May 7, 2008

RE: 55 Roberts Street – 066A-B-017 – R-5 Zone – Permit #08-0443

Bingham--
Third Floor Renovation--Plan
55 Roberts Street, Portland, ME
5 August 2008

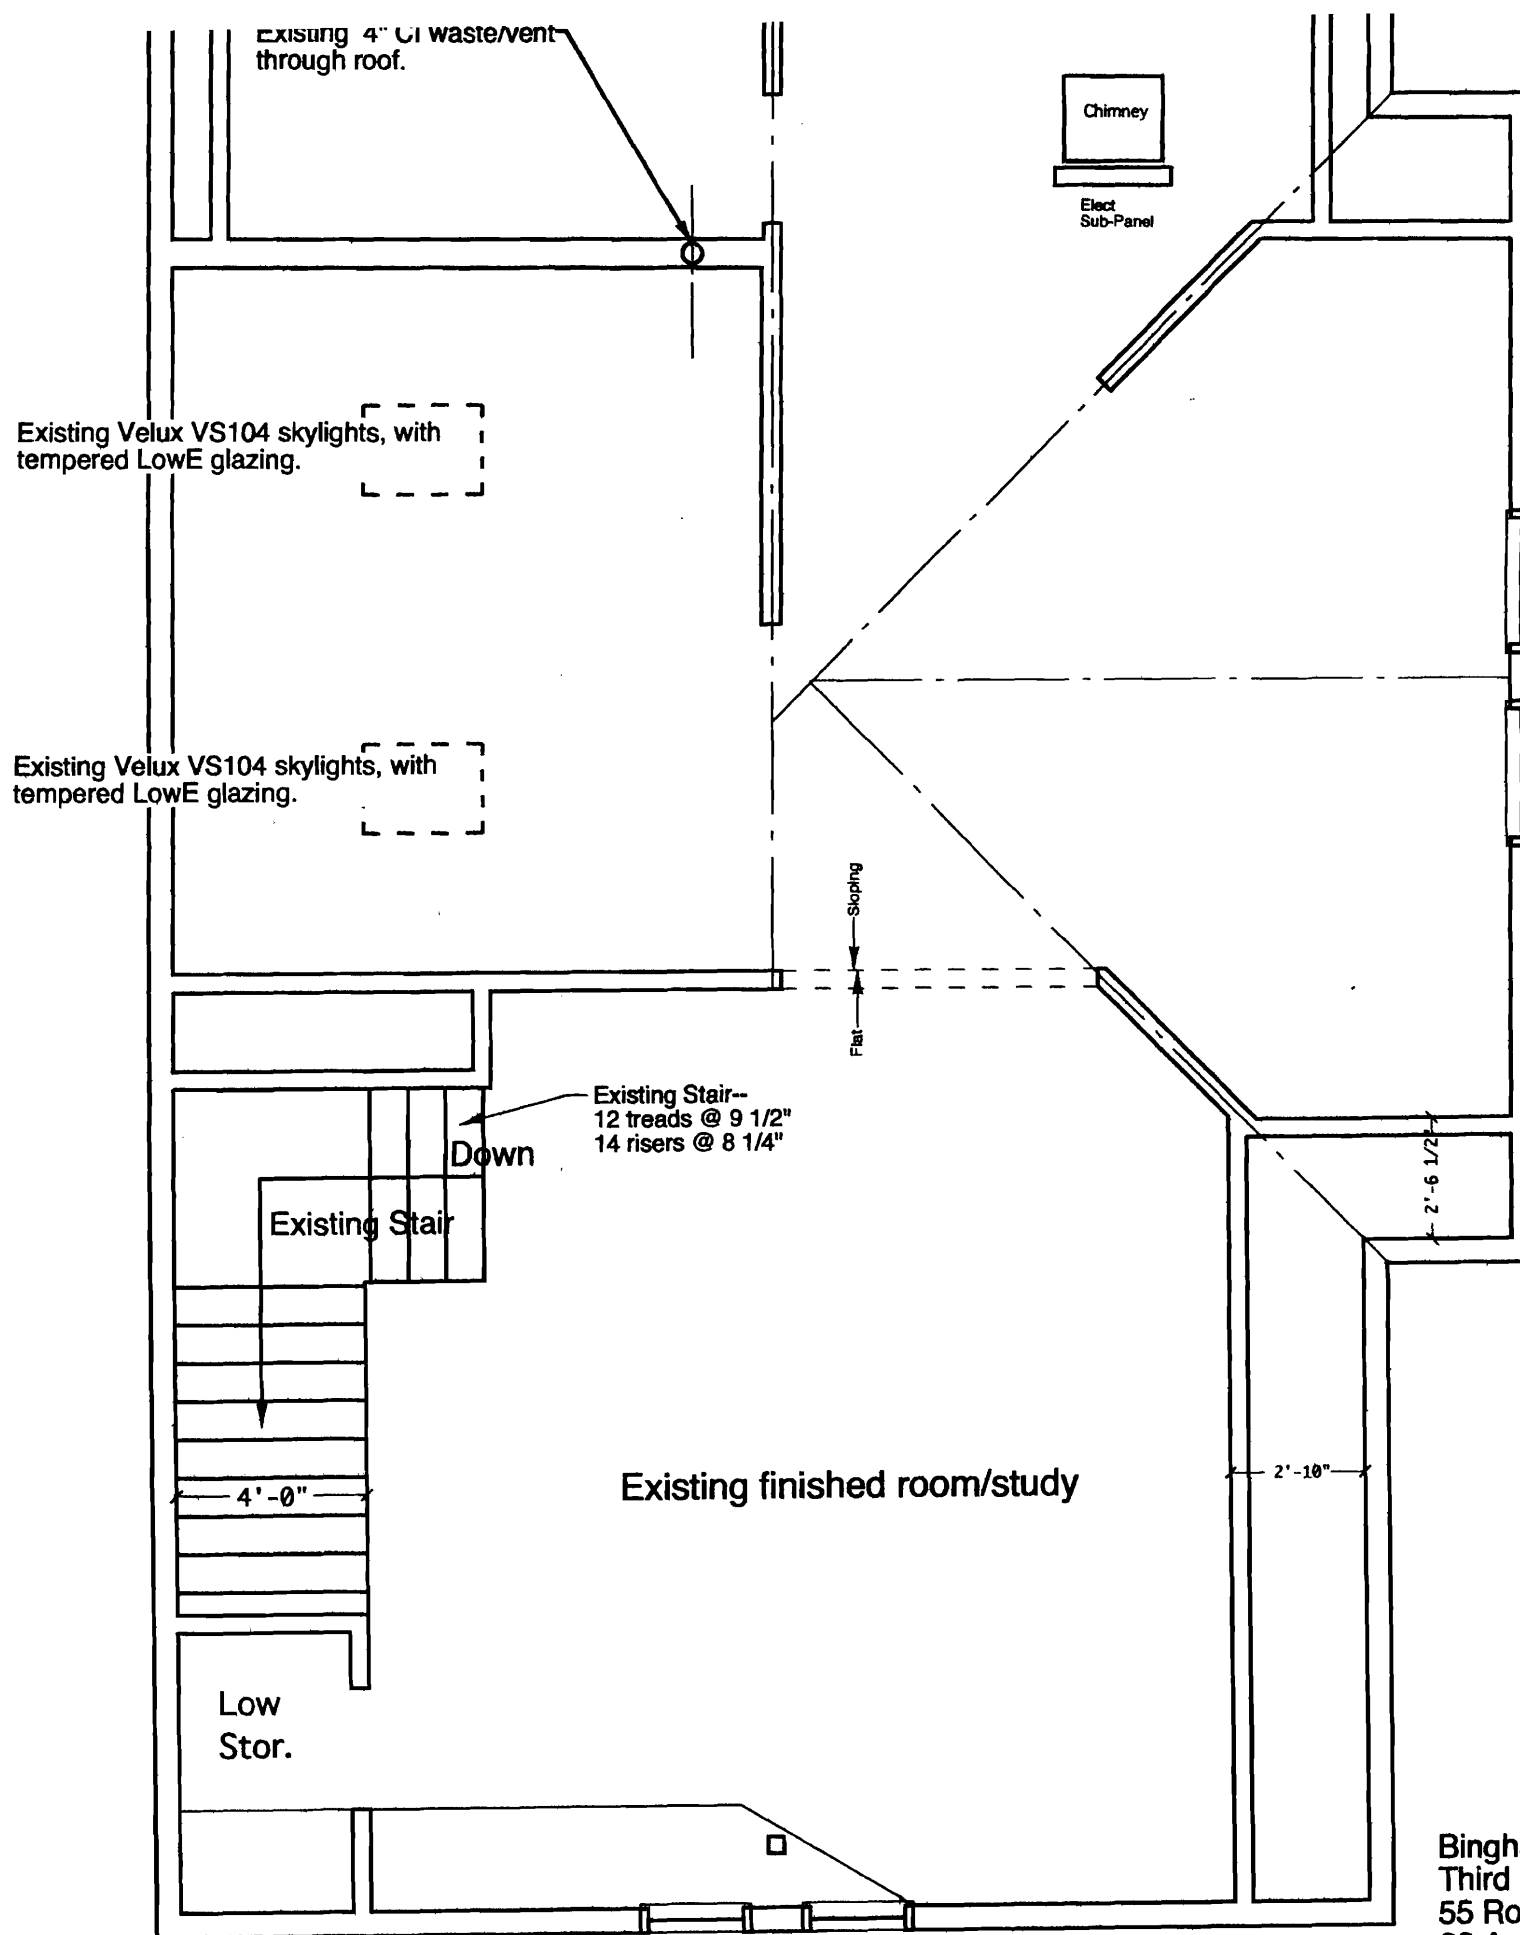
Your floor plan shows a separate apartment layout with a kitchen area, bedrooms, bathroom, separate electrical panel, and living room area which creates a third dwelling unit within your building.
